Ribble Valley Borough Council
Council Offices
Church Walk,
Clitheroe
Lancashire
BB7 2RA

Phone: 0300 123 6780
Email: developeras@lancashire.gov.uk
Your ref: 3/2026/0310
Our ref: 3/2026/0310/HDC/KW
Date: 23 July 2026

Location: High Head Barn Moss Lane Chipping PR3 2TR
Proposal: Proposed Change of use of existing buildings from cheese manufacture to a welding and fabrication workshop (Use Class B2) and change of use of land and erection of a storage building for use in association with an agricultural contracting business (Use Class B8).
Grid Ref: 363271 442742

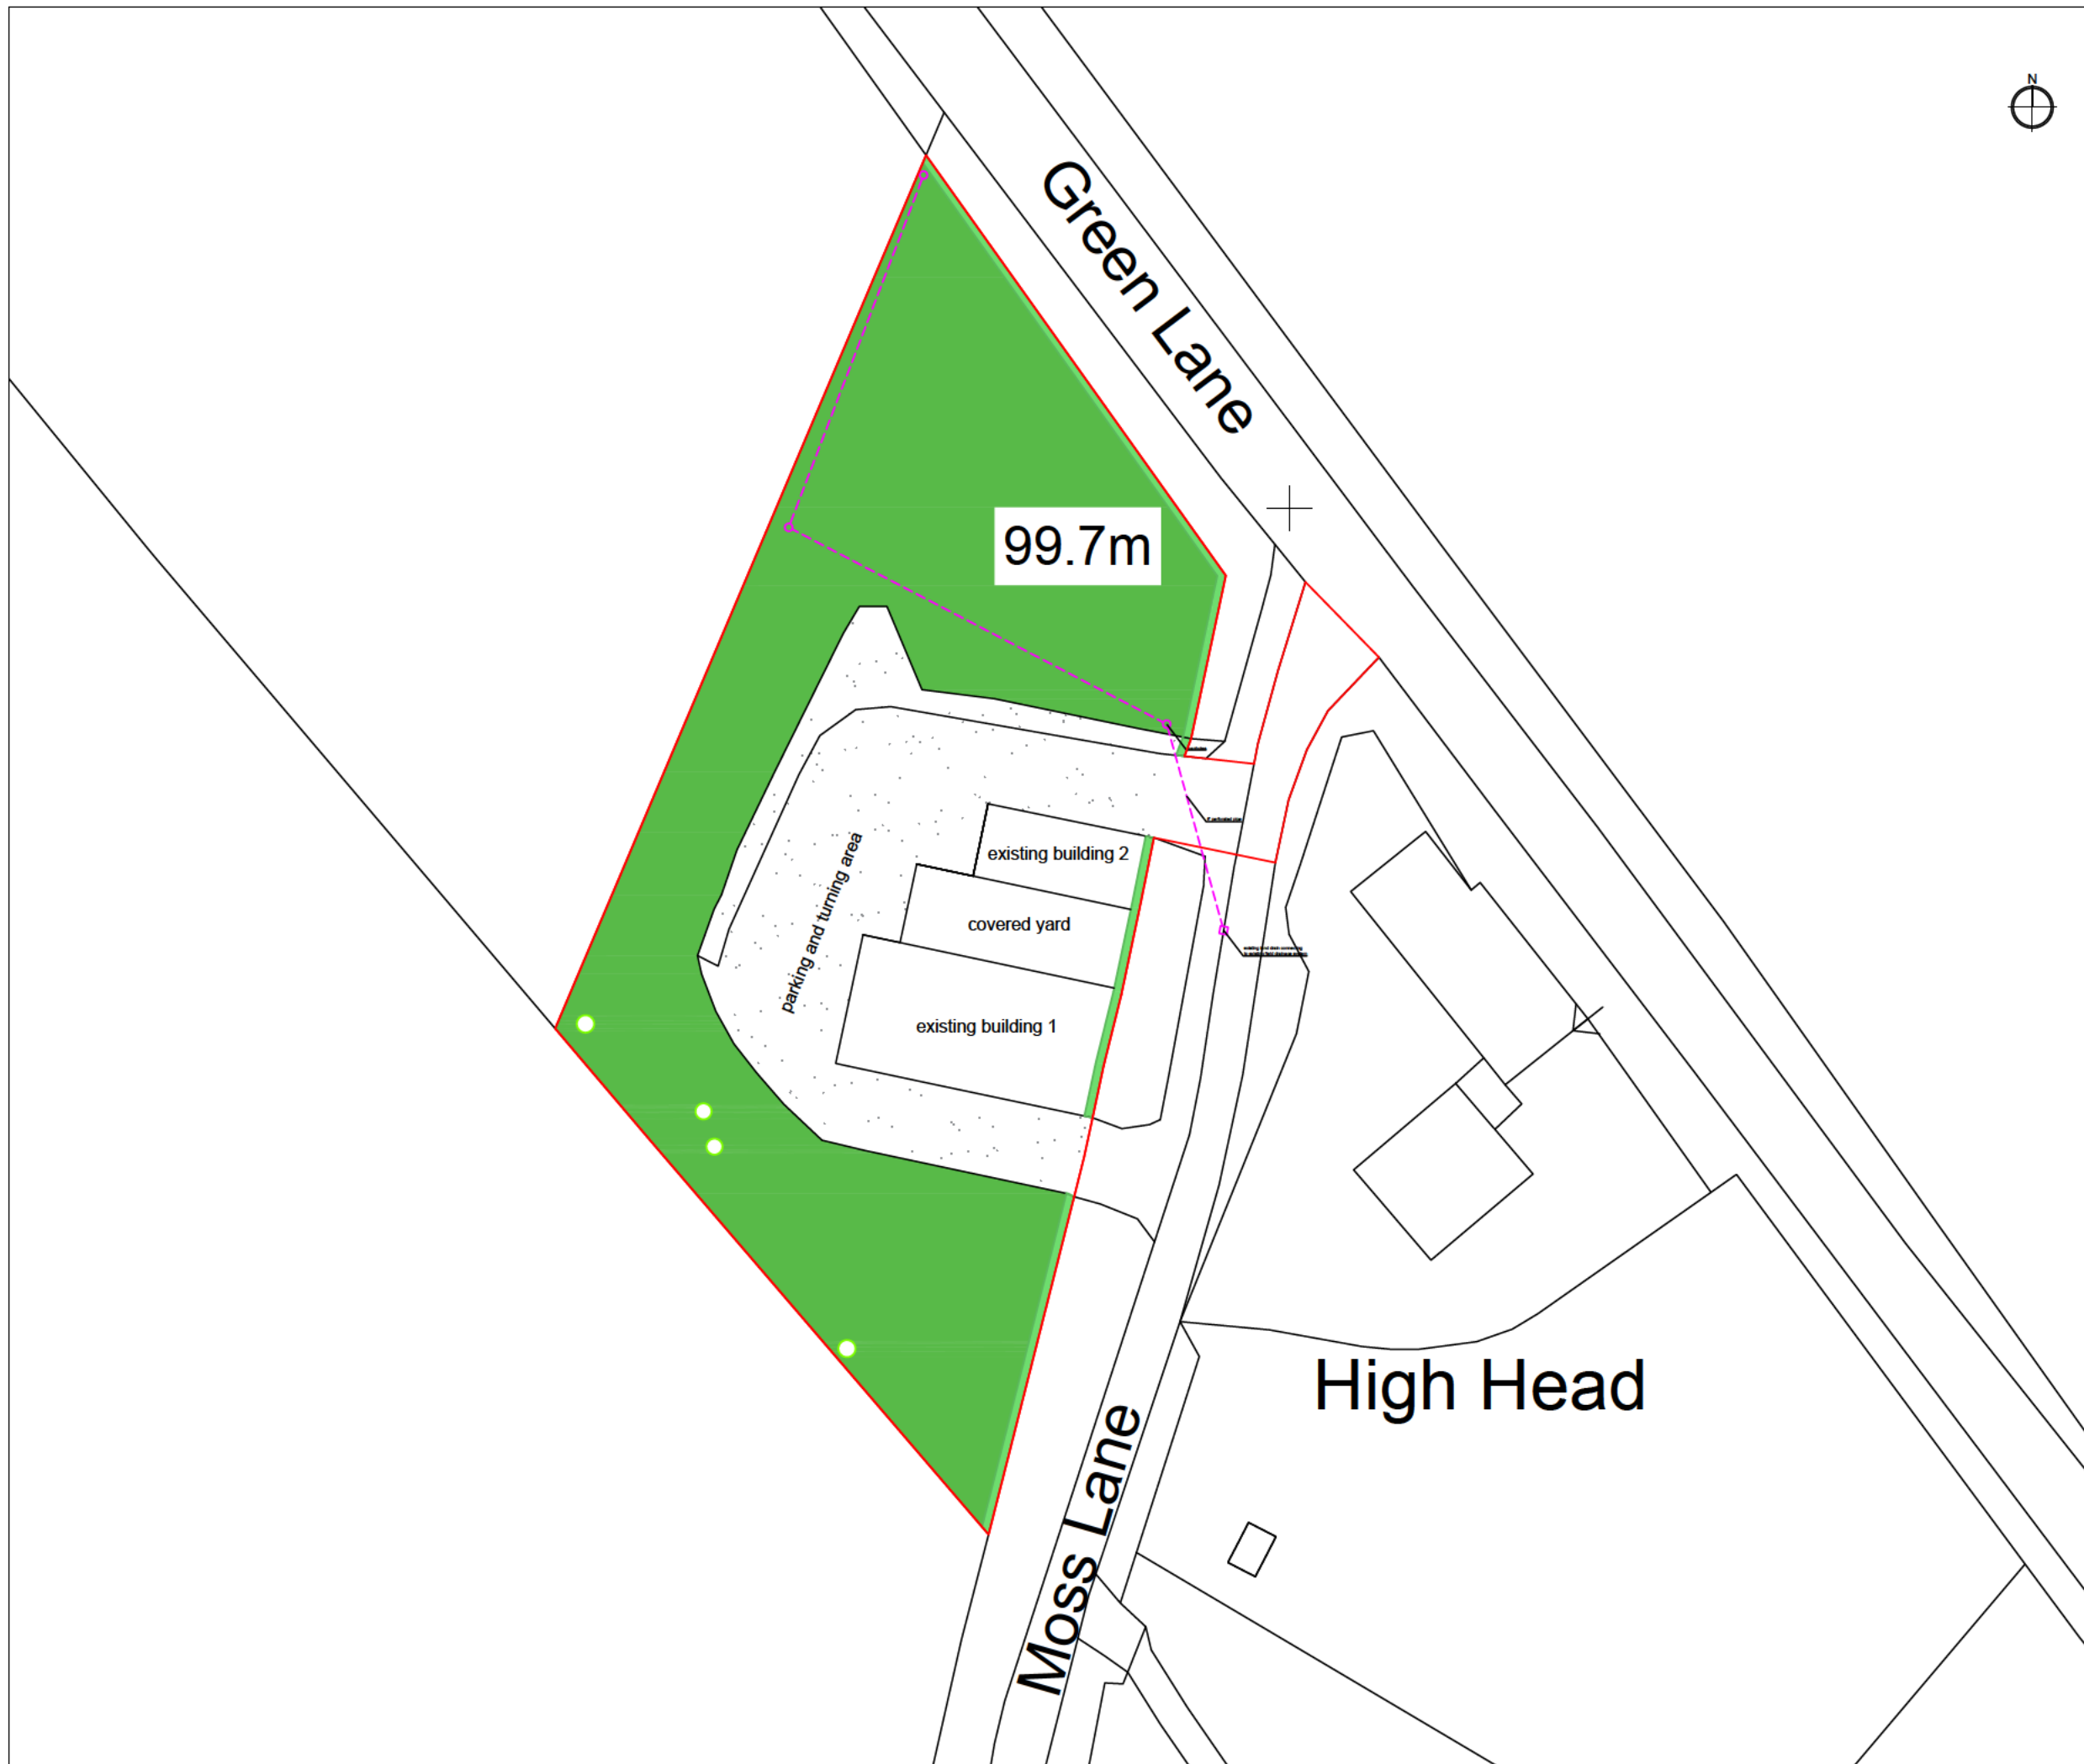
It is understood that the site benefits from 7m wide access and an internal access track that links around the site and allows for ingress and egress in a forward gear. There is also room for vehicles to be parked within the site.

This site would also benefit to provide a track between the proposed building and the existing hardstanding area to reduce the risk of mud and other debris being dragged across the site, although there is at least 10m of hard standing fronting the access into the site which would reduce the risk of debris being dragged onto the adopted highway network.

Proposed Building

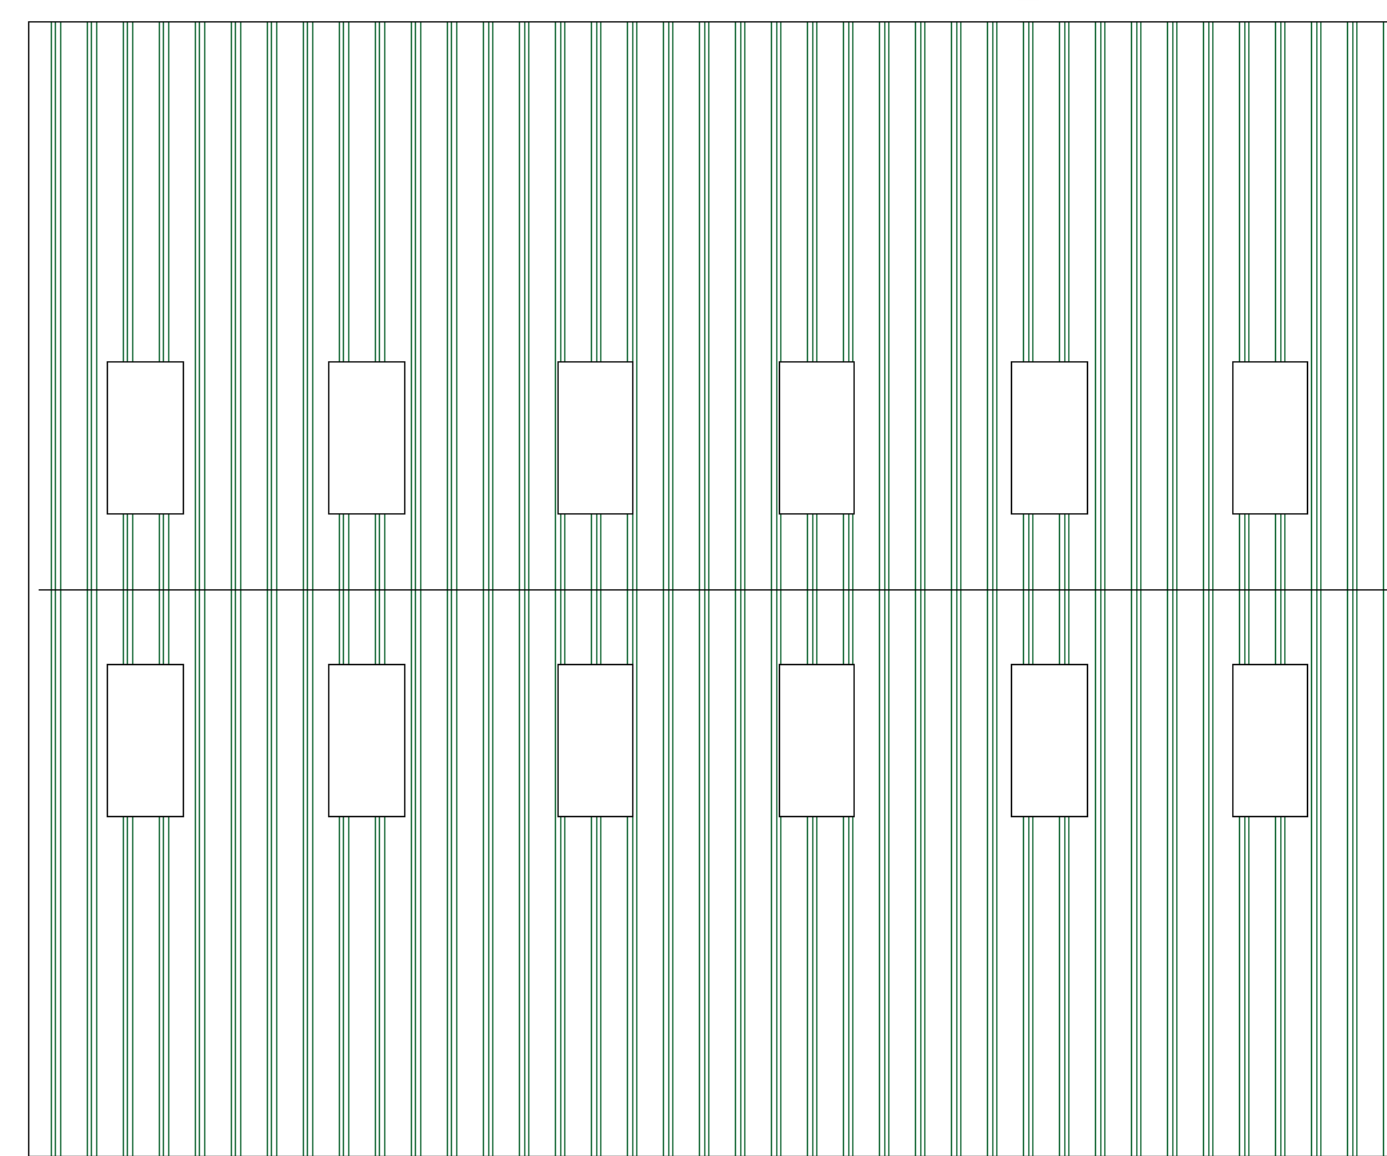
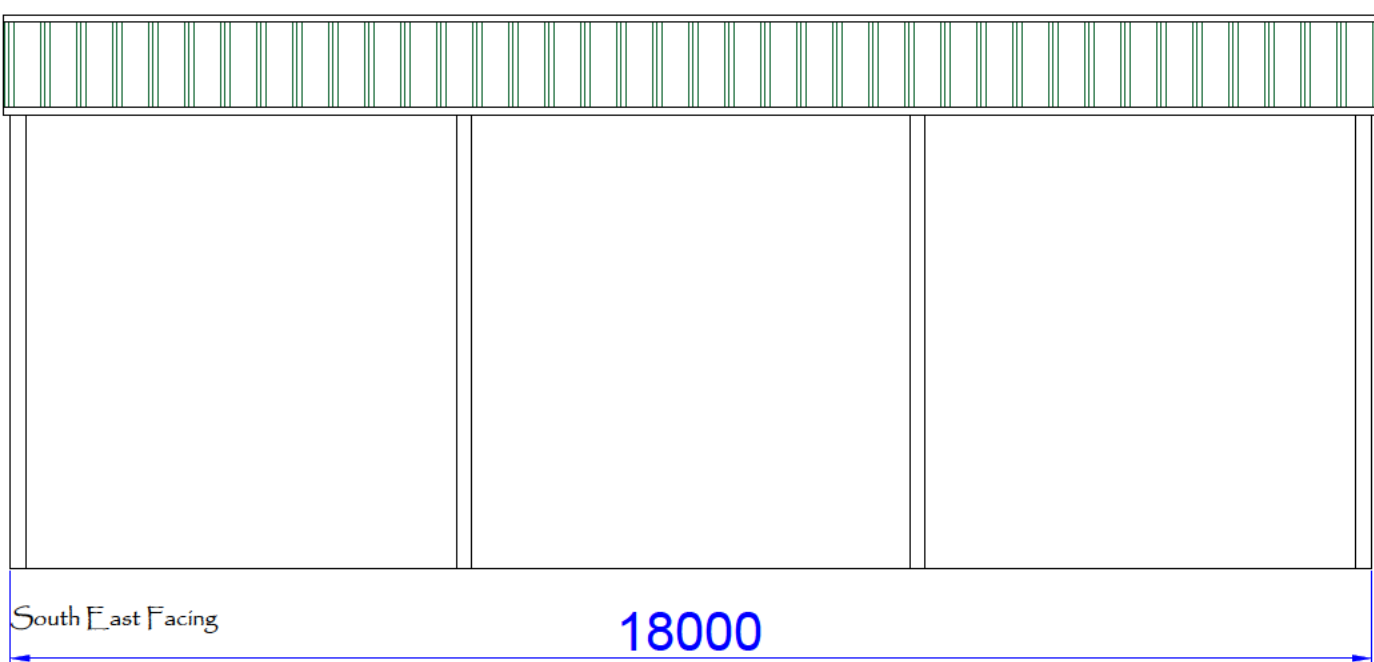
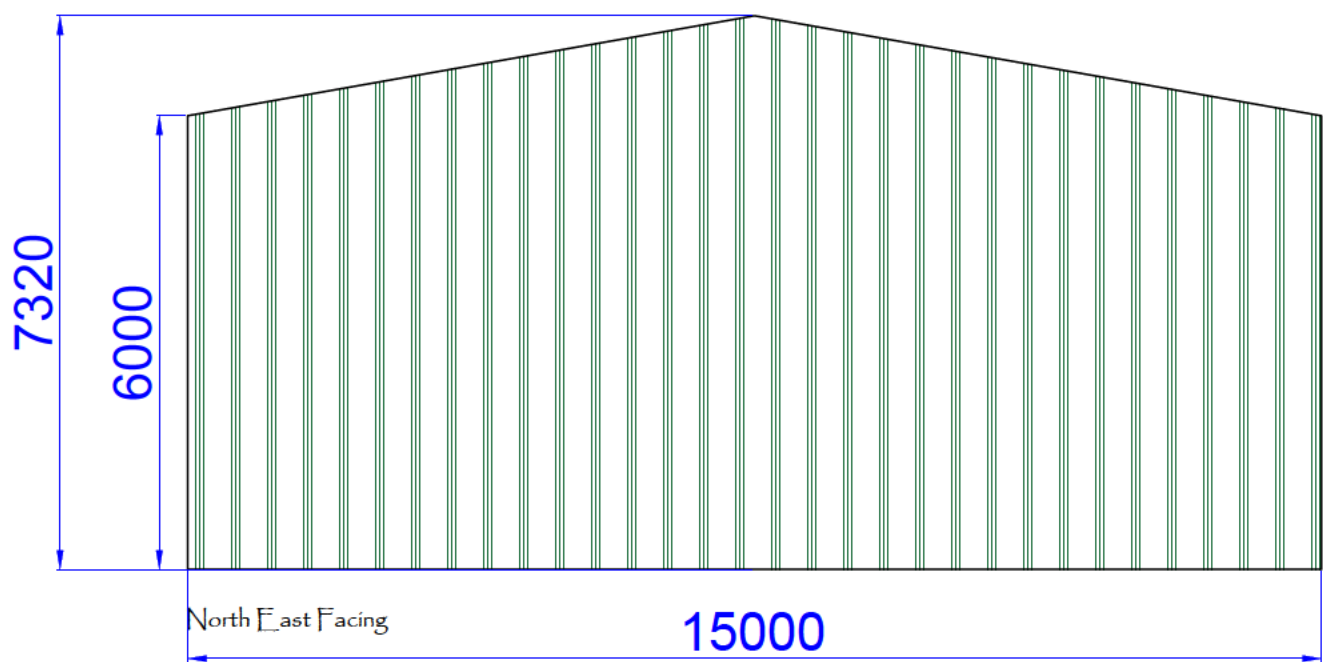
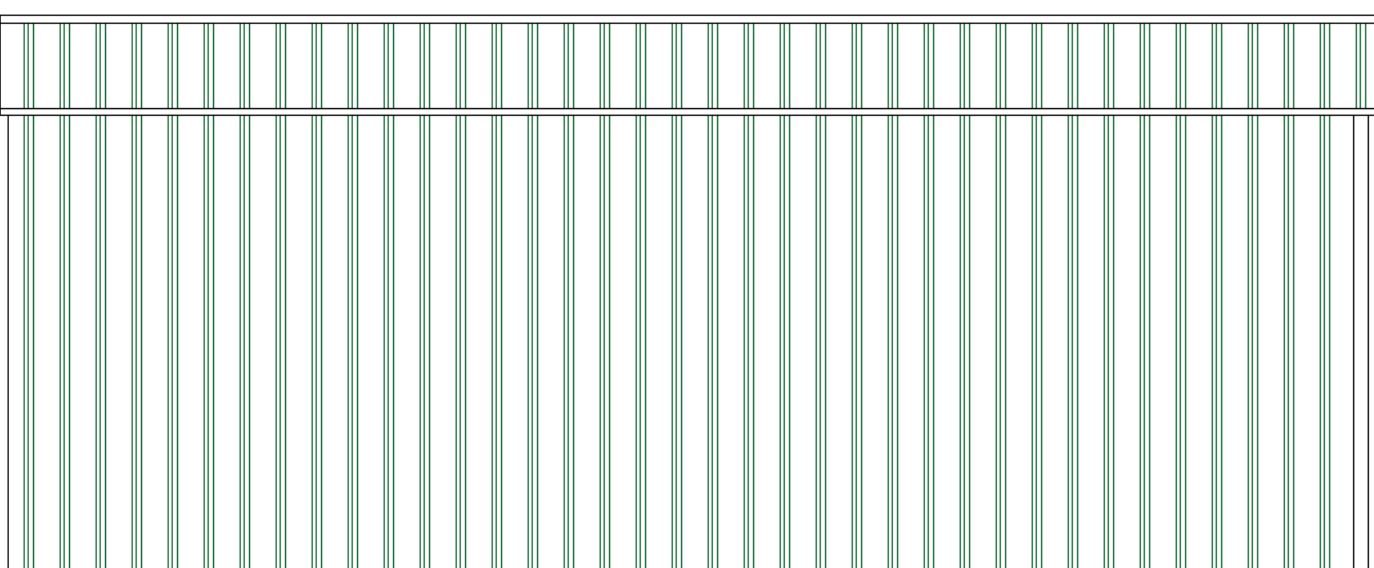
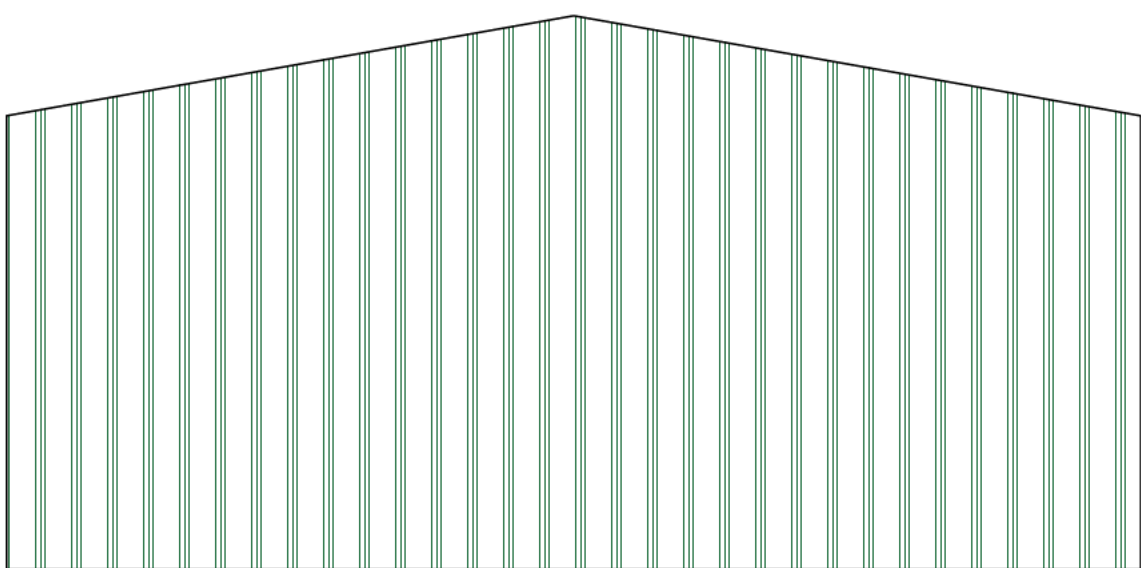
The proposed new building will provide storage for an agriculture contractor business; however, the LHA would look to condition the building to be linked to the existing provisions on site to ensure the buildings are not operated separately in the future in order to ensure vehicle movements remain limited.

1. The storage building hereby permitted and the existing buildings within the application site shall only be used in conjunction with one another under the control of the same owner and/or operator. The buildings shall not be occupied, leased, sold, let, managed, or operated as separate and independent units without the prior written consent of the Local Planning Authority.
